DECISION DELEGATED TO DEVELOPMENT MANAGER

Application No: H17-0149-19 **Applicant:** Mr & Mrs Needham
Proposal: Erection of 5 detached dwellings (Outline Approval H17-0563-16)
Location: Land Adjacent: 72 Station Road Surfleet Spalding
Terminal Date: 5th April 2019

PLOT 5

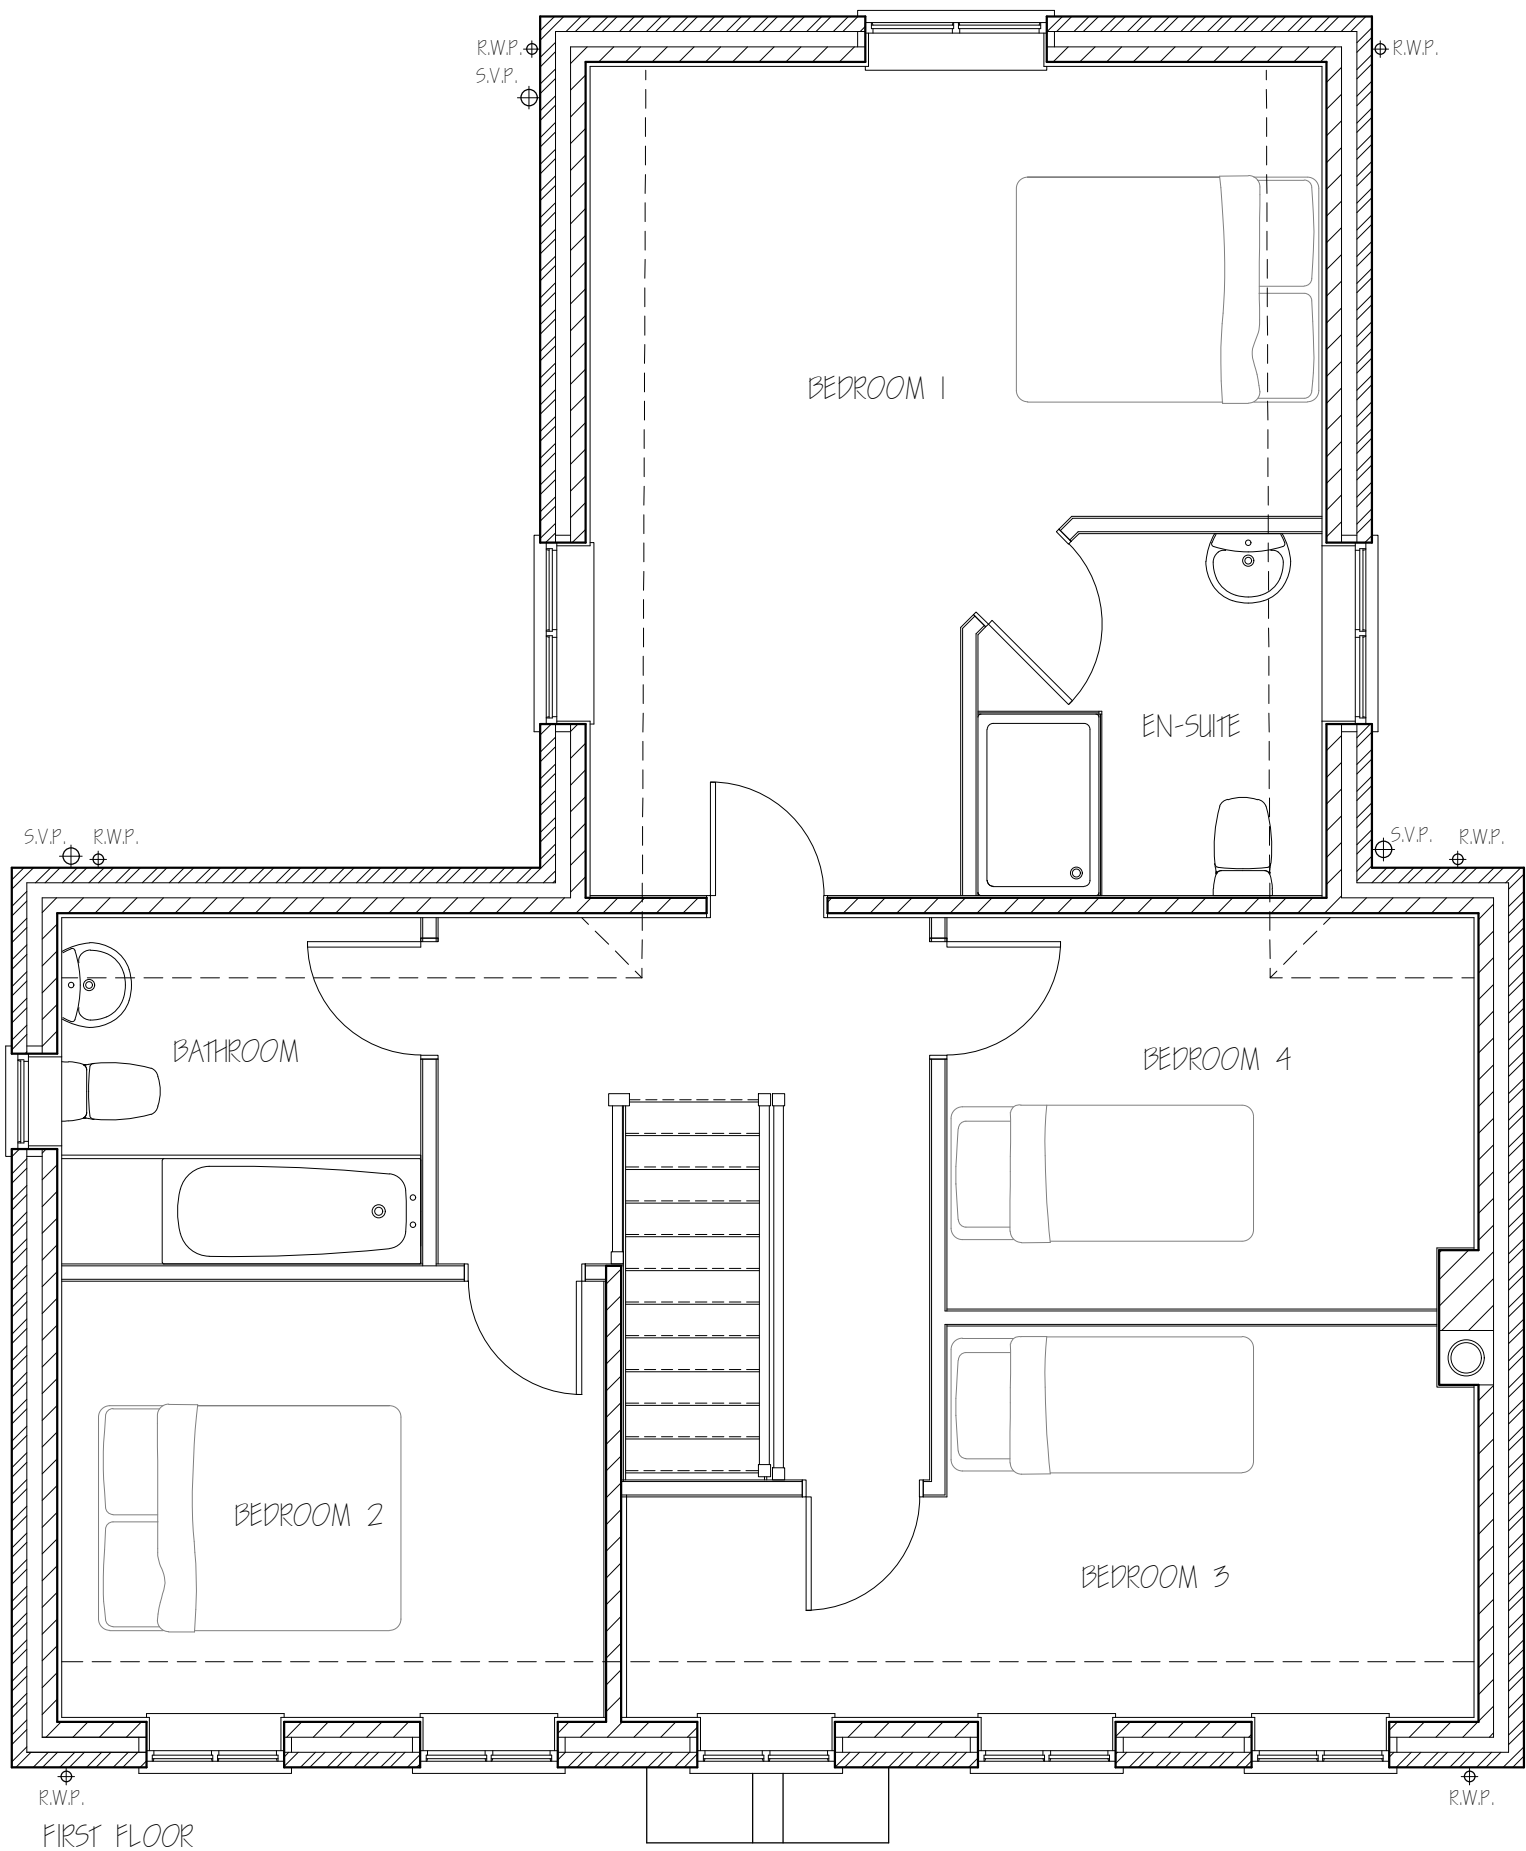
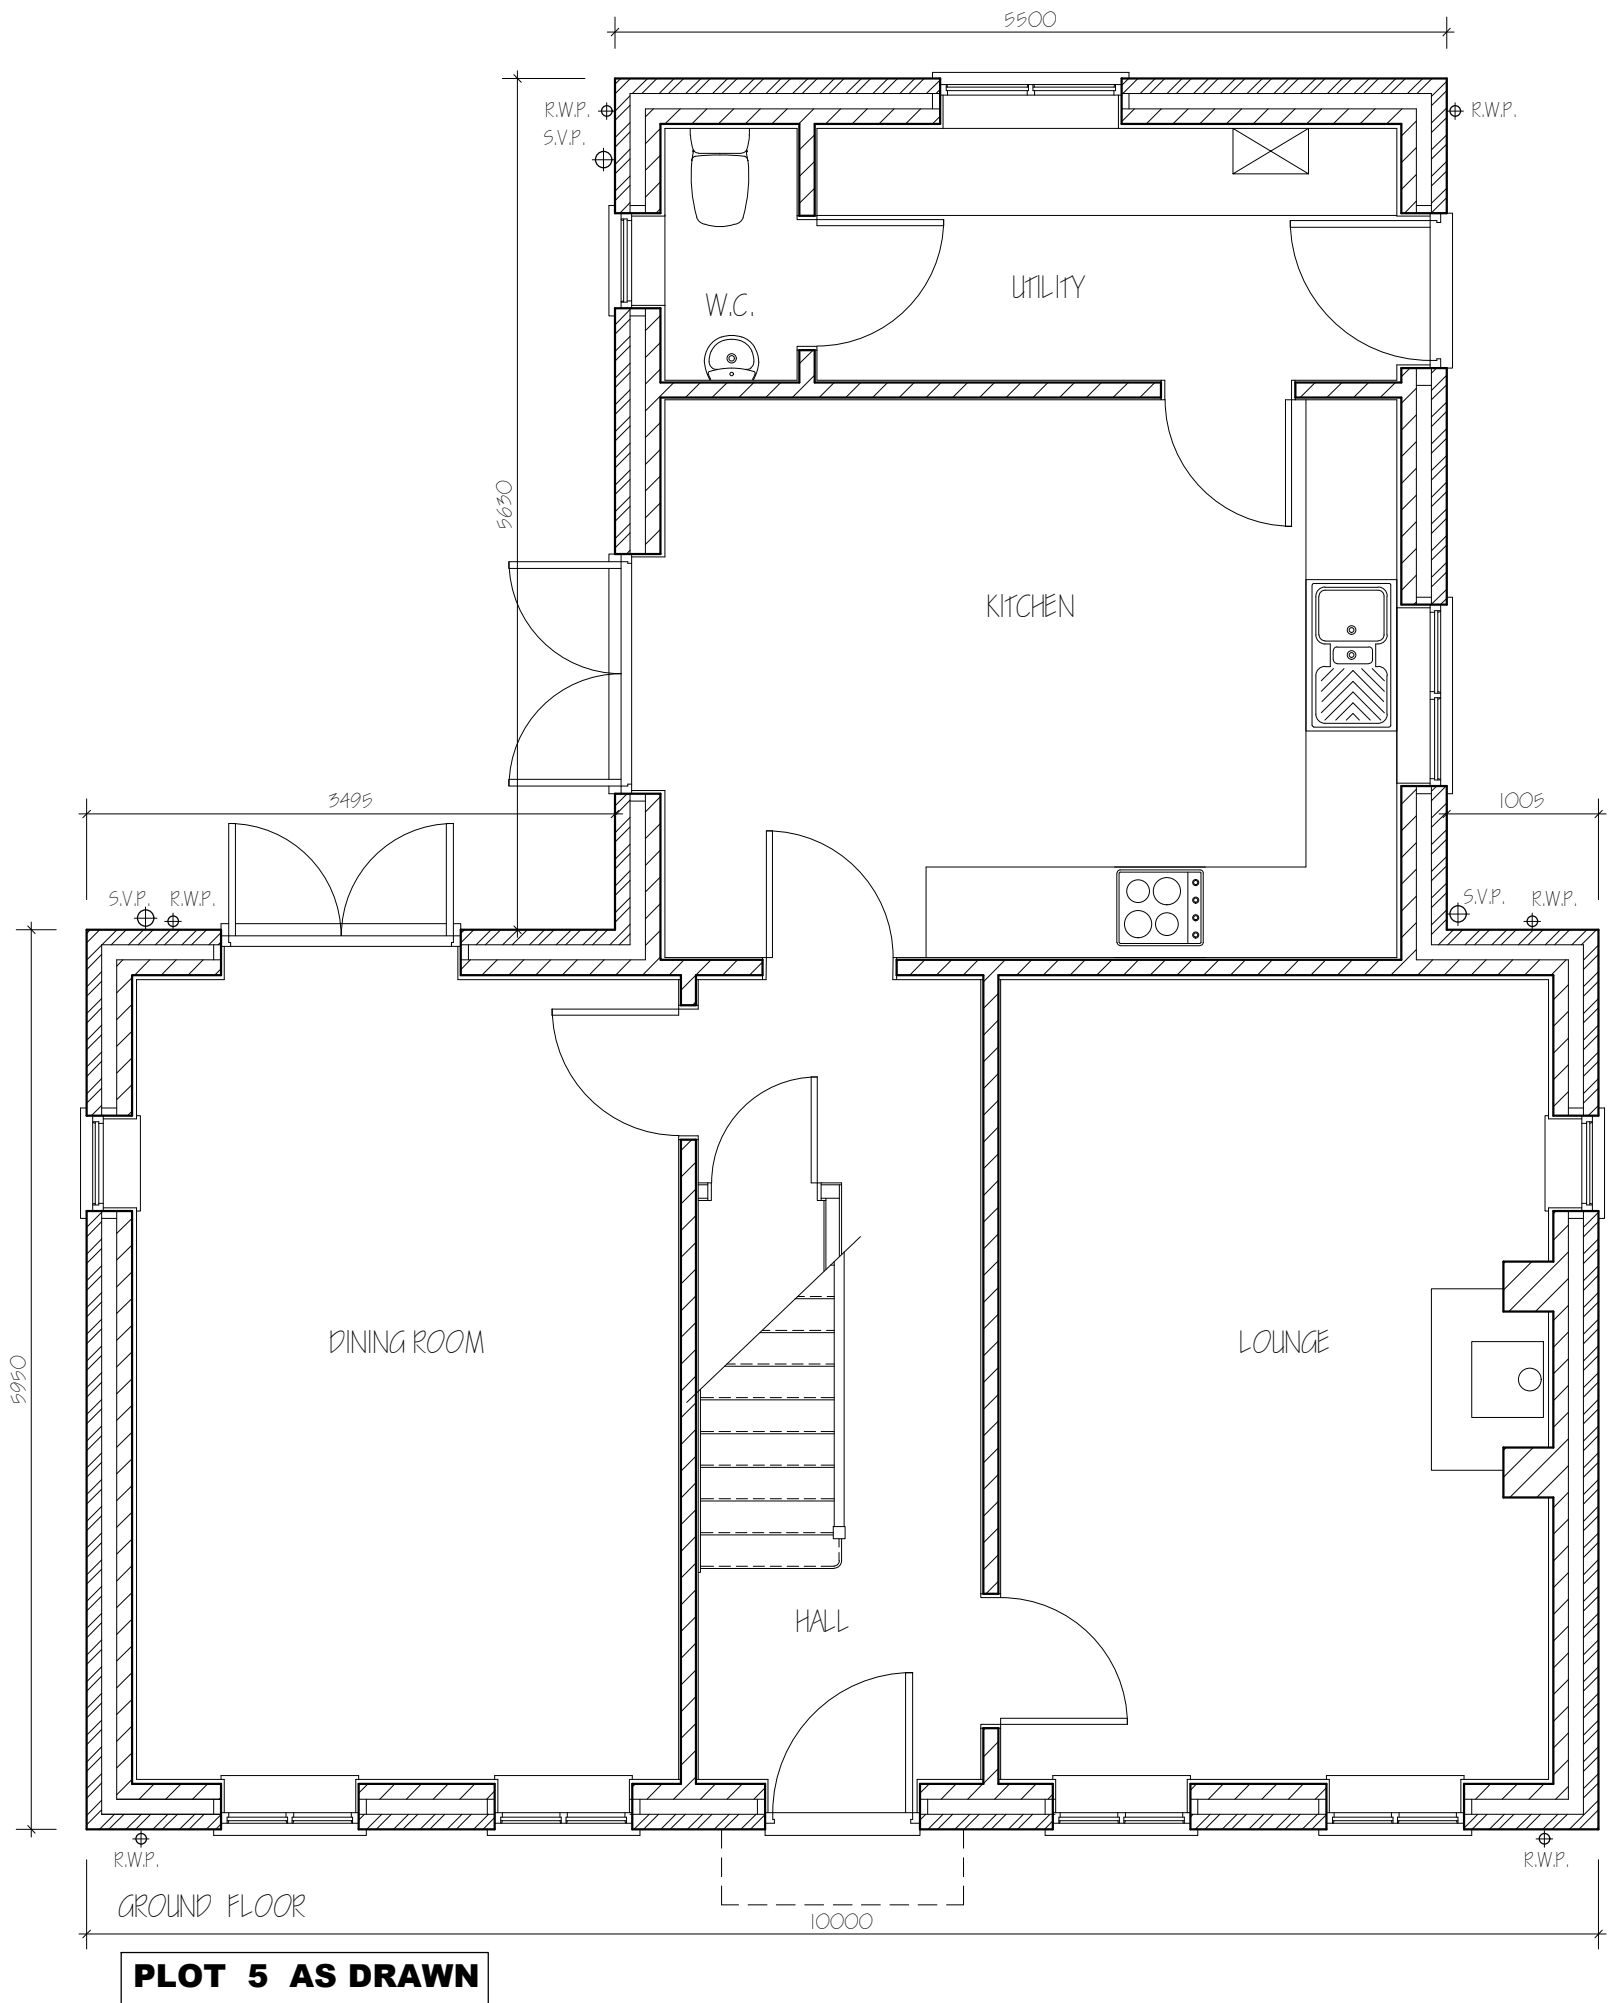
Plot 5 would be approx. 10m away from the existing dwelling to the east and so it would not have an overbearing effect or result in an unacceptable loss of light. Furthermore, plot 1 would be approx. 2.5m from the existing dwelling to the west at the closest point which is acceptable.

BLOCK & LOCATION PLAN	
Scale 1:200 1:2500 @A1	Drawing No. 1815-01-A
Date. JAN. 19	Drawn. J.C.

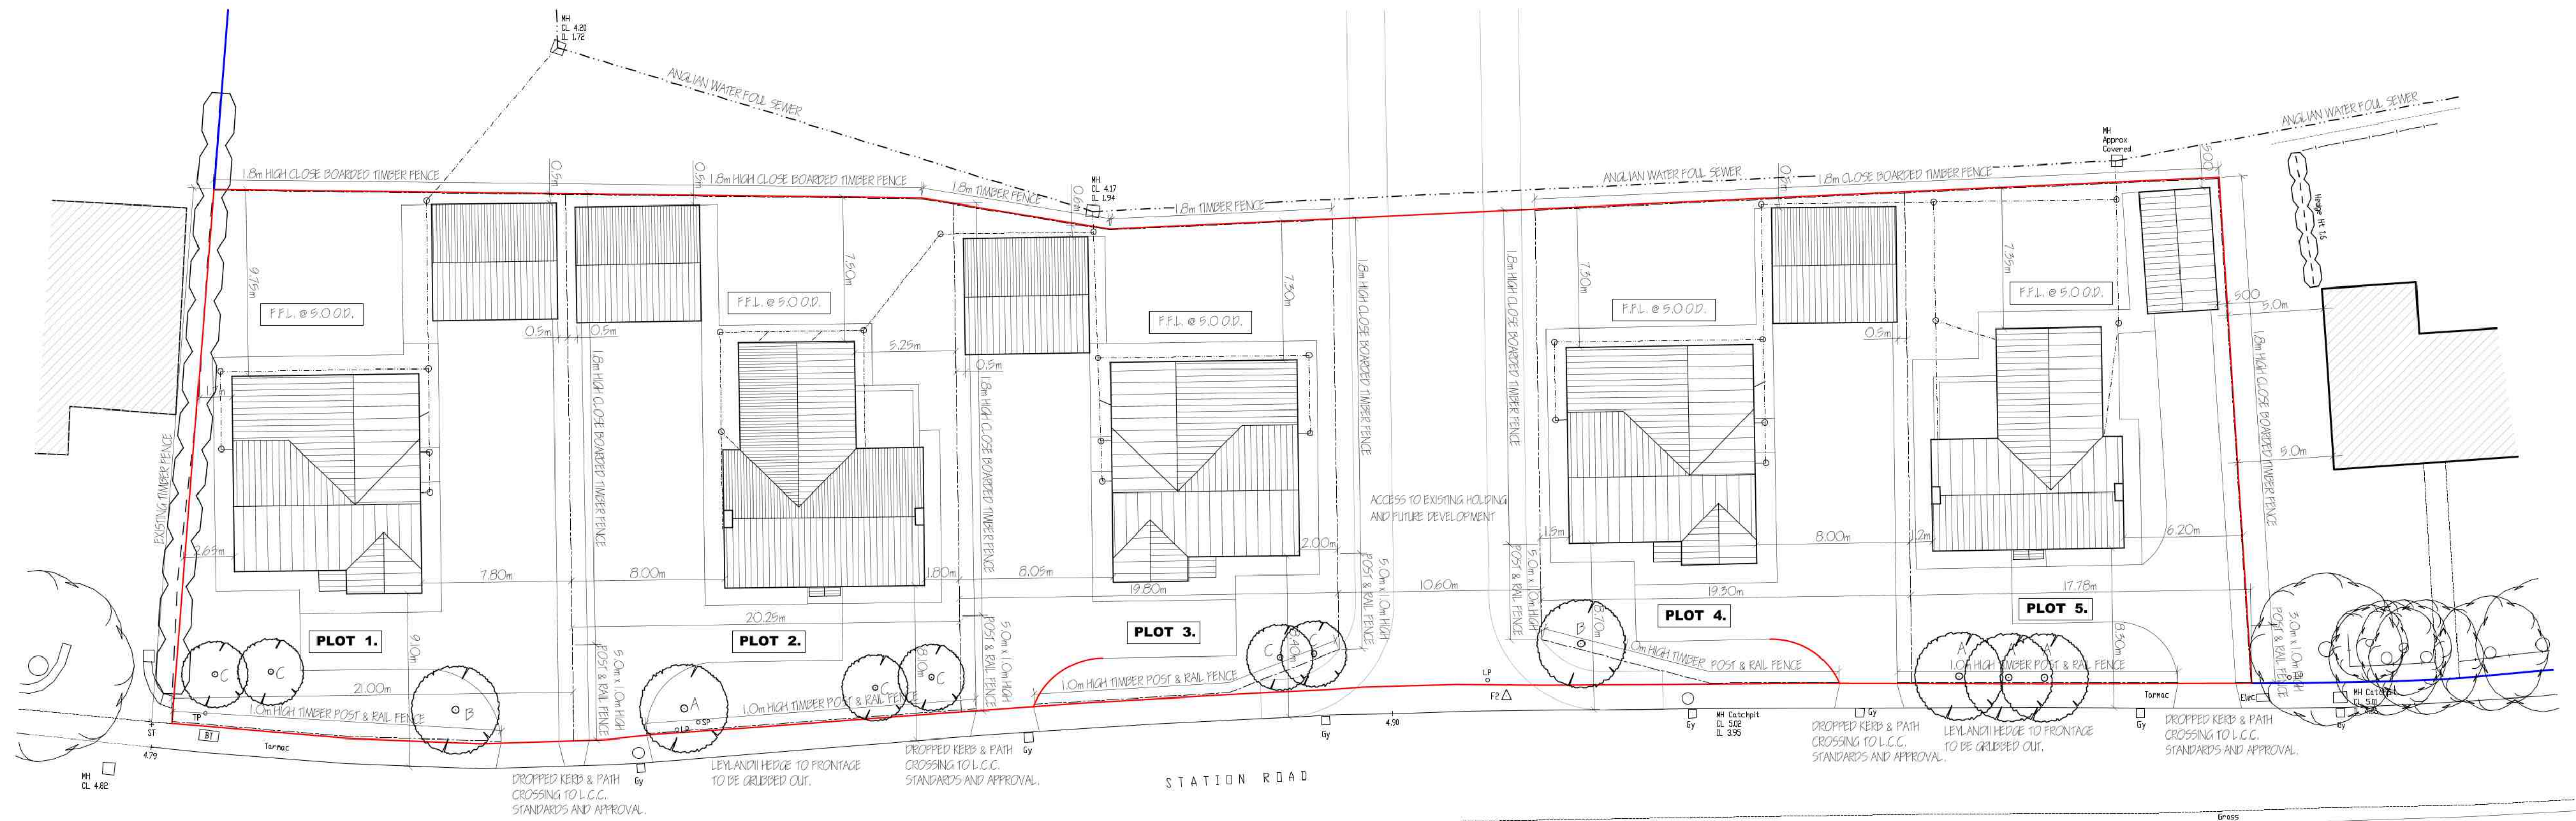
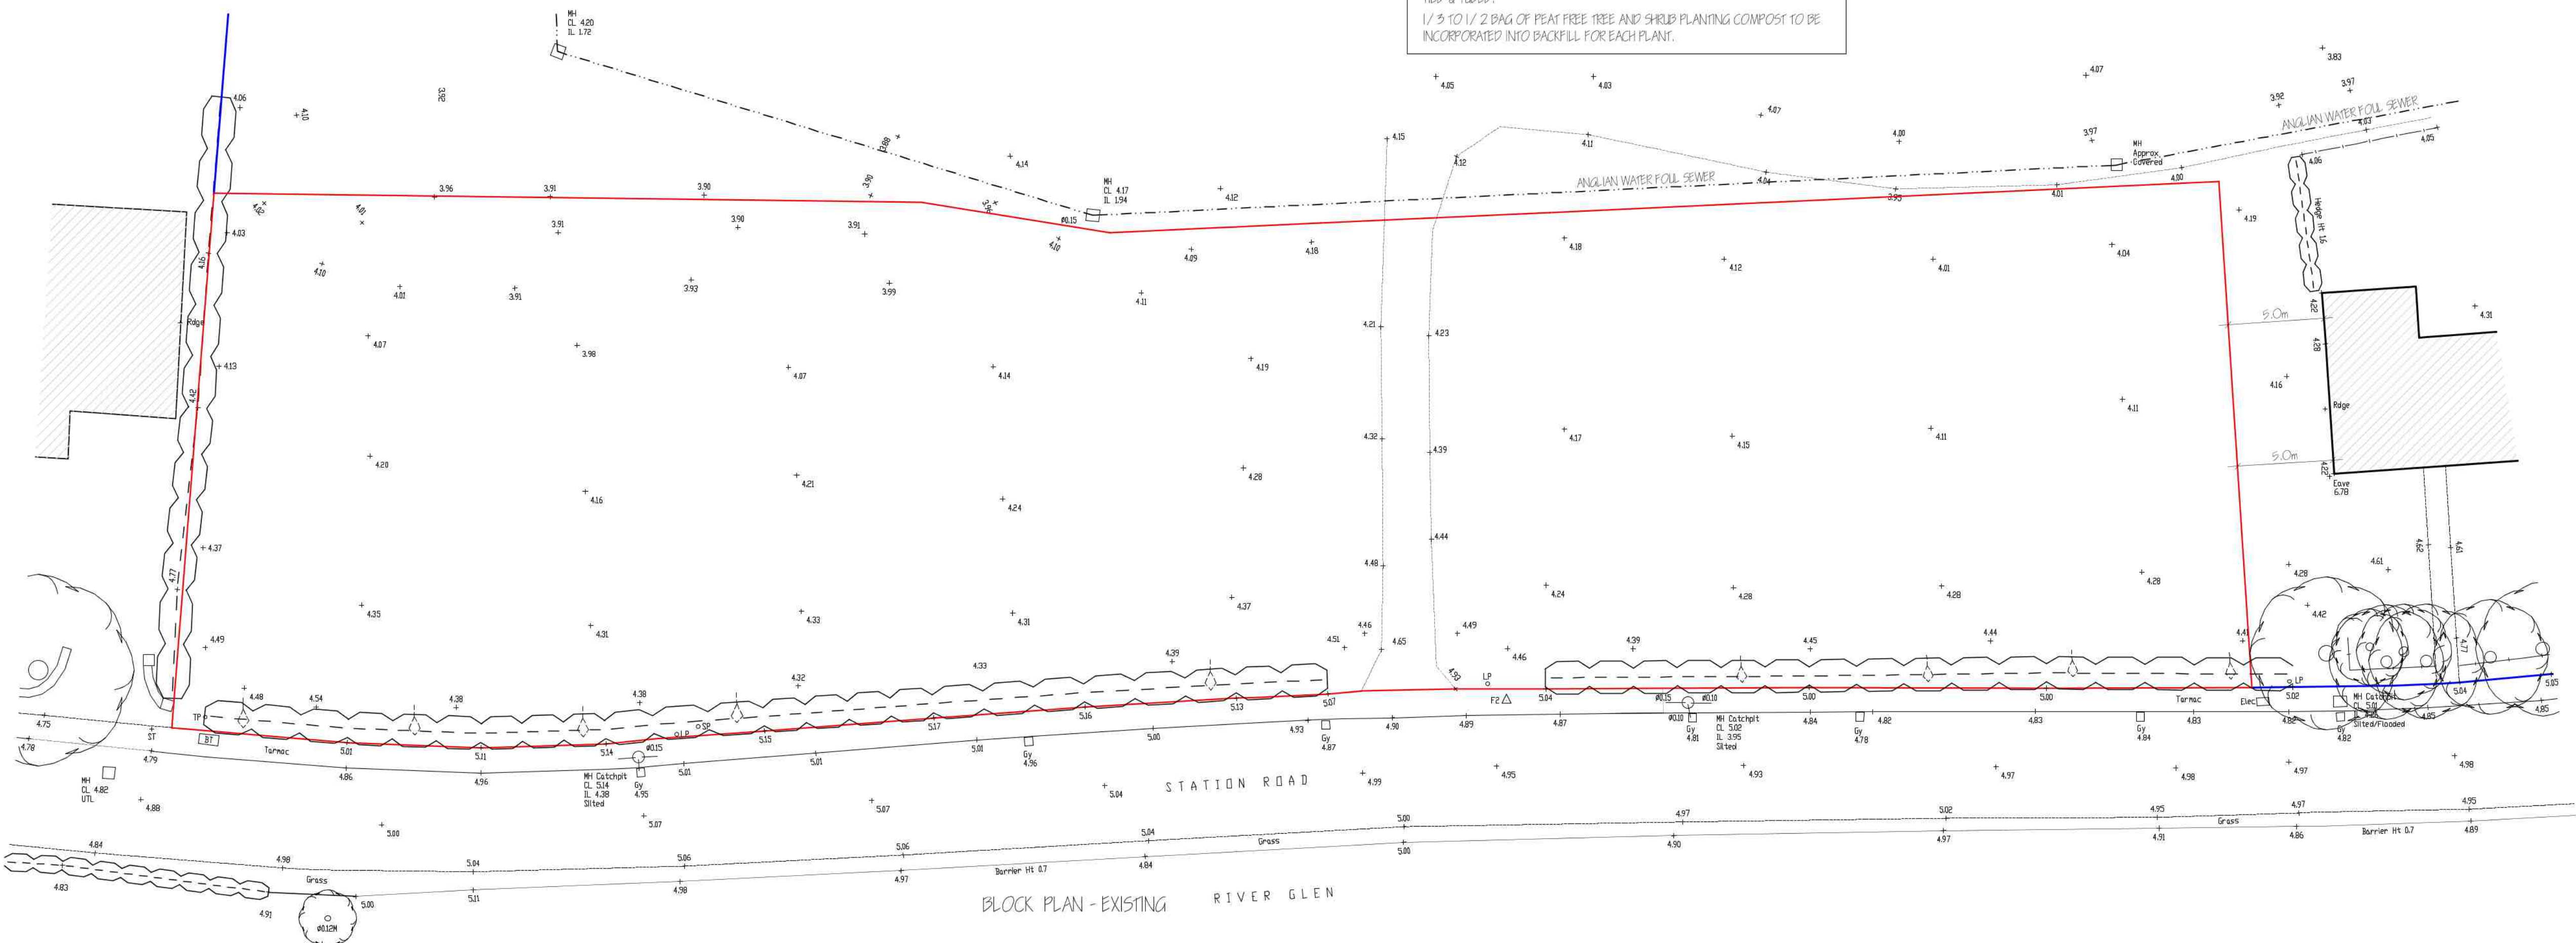
Condition 8 of the outline approval requires finished floor levels to be set at 500mm above existing ground level. Finished floor levels are proposed to be 5.0m OD, which is acceptable taking into account existing site levels.
